90-102 Regent Street, Redfern (SSD-10382) – Waste Management

This letter addresses the issues raised in **Point 6. Waste Management** in the City of Sydney's letter to DPIE dated 21/5/21.

BASEMENT FLOOR PLAN

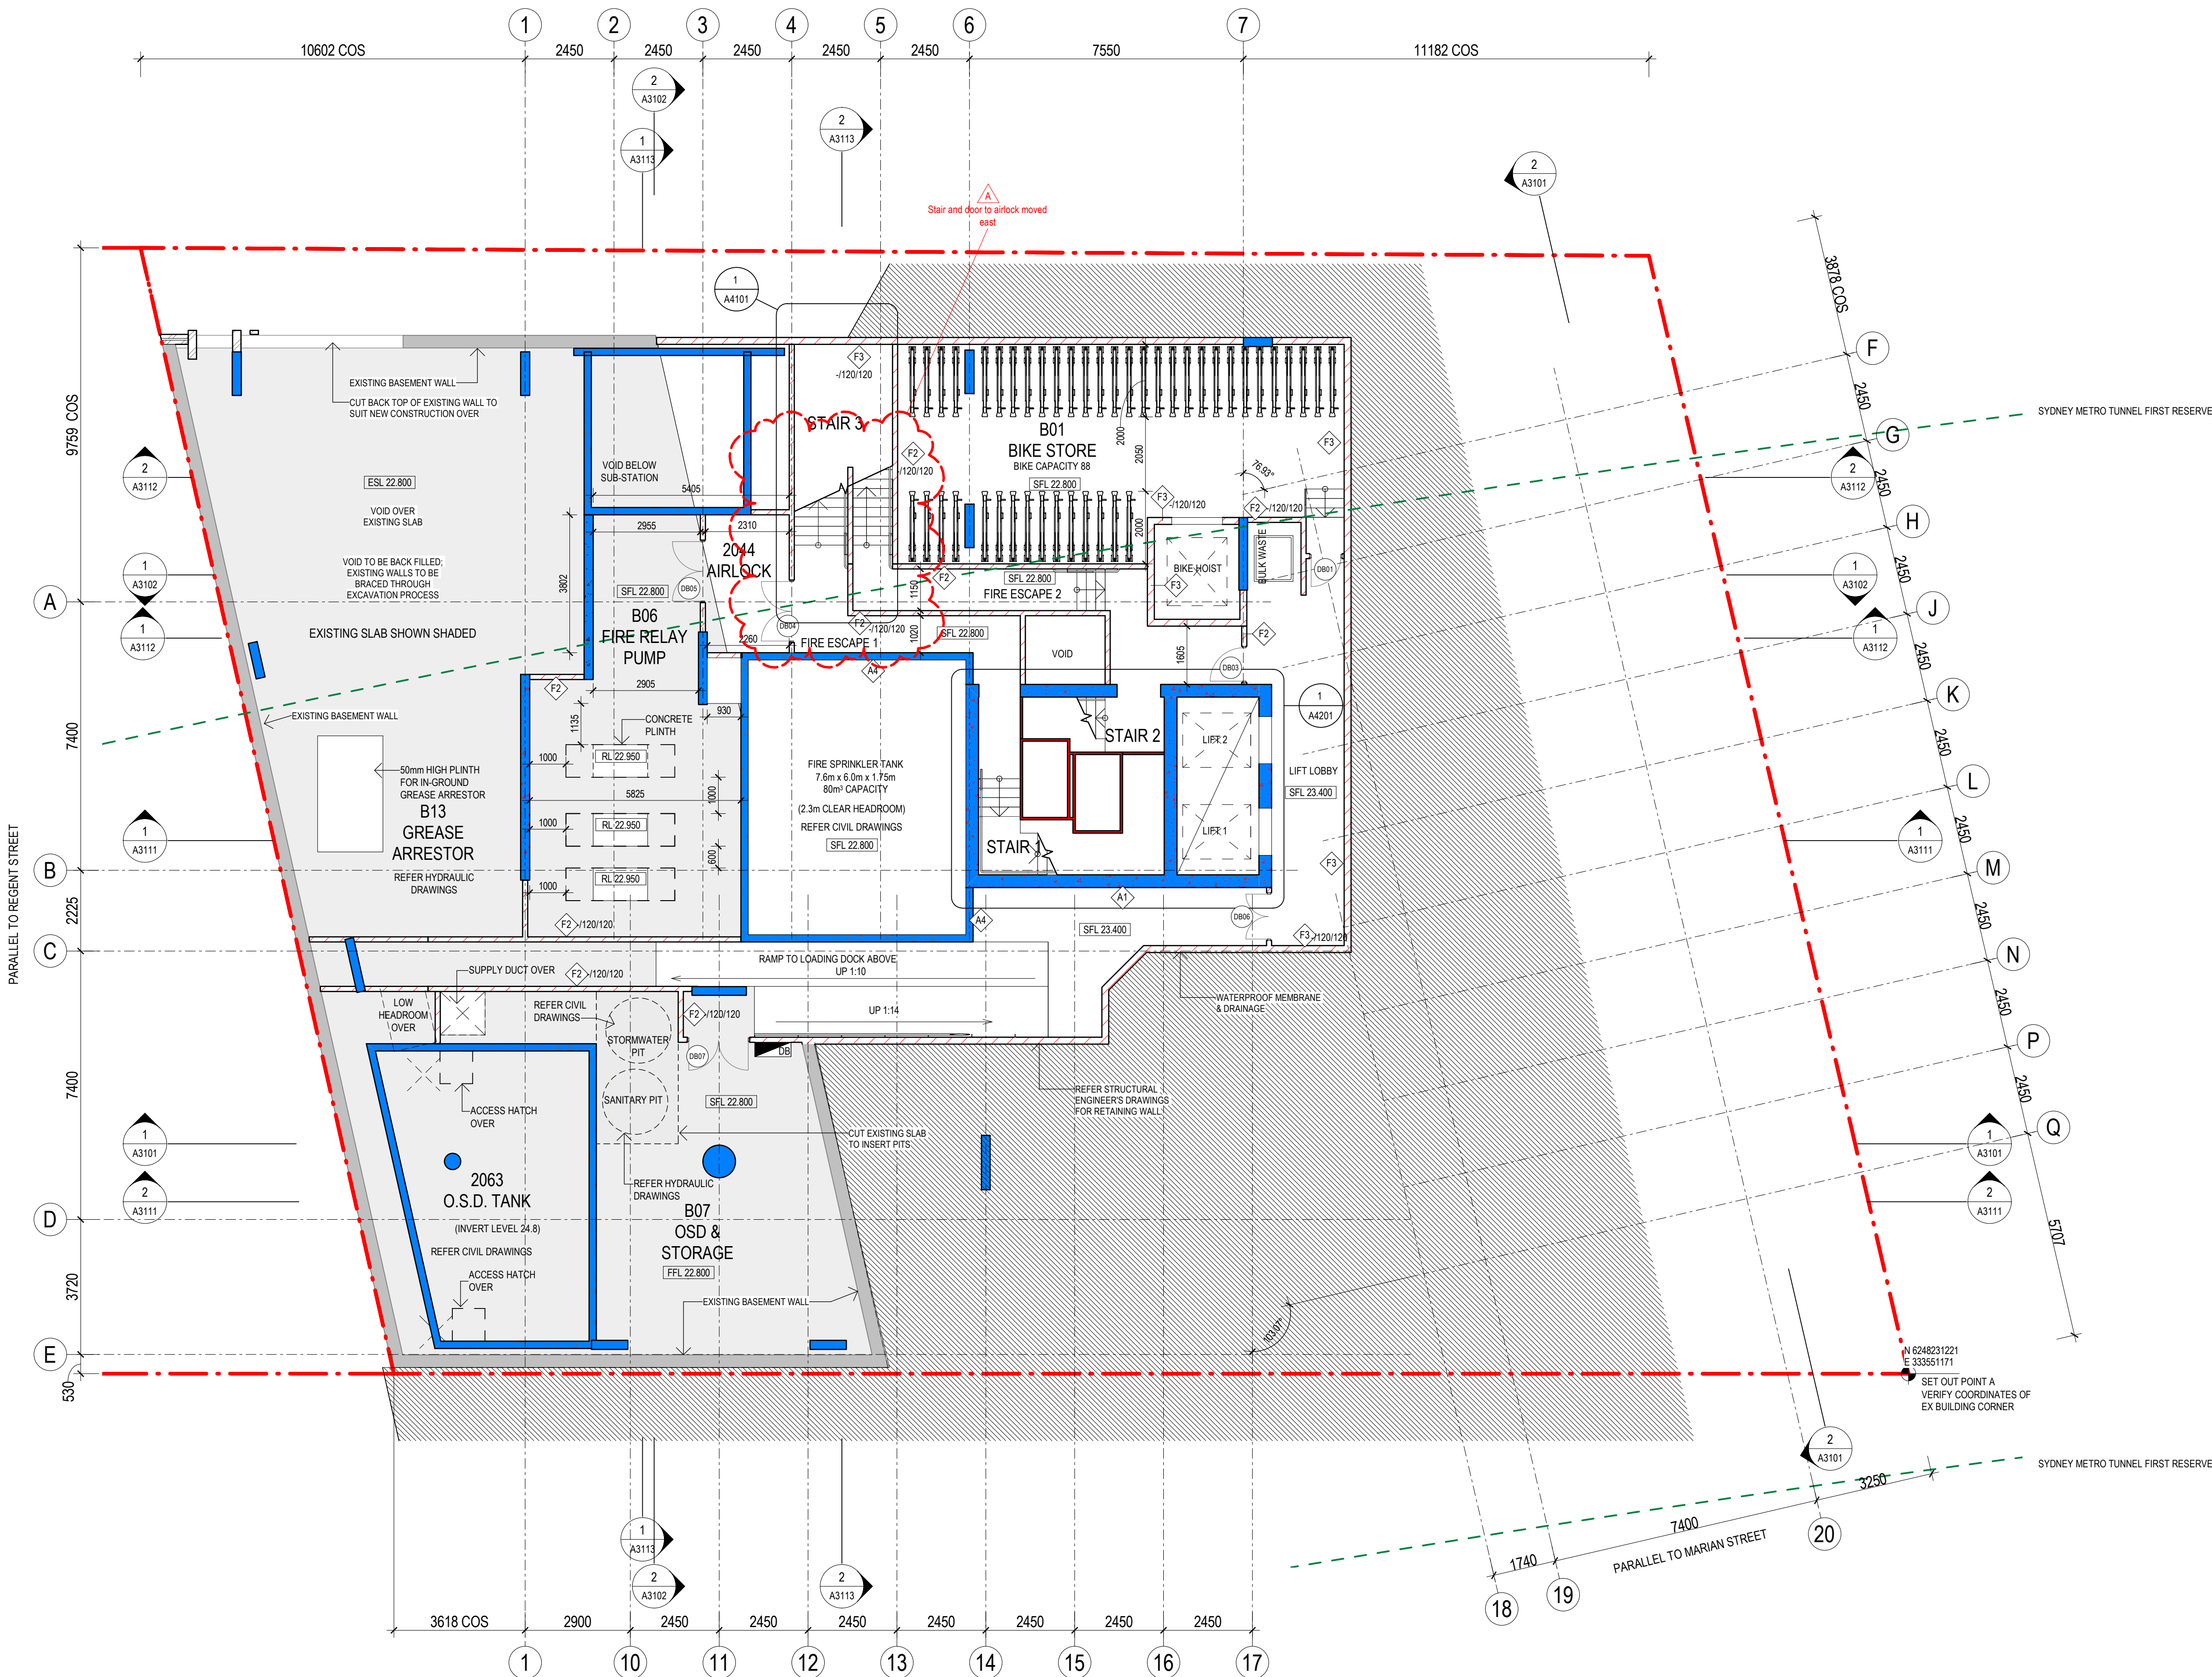
There must be separation between residential and commercial waste/recycling storage areas. These waste storage areas and bulky waste storage areas must be separated and clearly labelled on the architectural plans. At least 2 square meters of commercial bulky waste storage space must be provided for the retail space as well as space in close proximity to retail premises to store re-usable items such as crates and pallets so that storage in the public space can be avoided.

Residential and commercial waste/recycling storage areas are separated and clearly shown on architectural drawings as shown below:

A temporary 4 square metre holding room will be constructed in the Basement for bulky residential waste. As shown below this room is in close proximity to the residential lifts: residents will deposit items in this room and Building Management will transfer the material to the main 4 square metre residential bulky waste storage room on Lower Ground level.
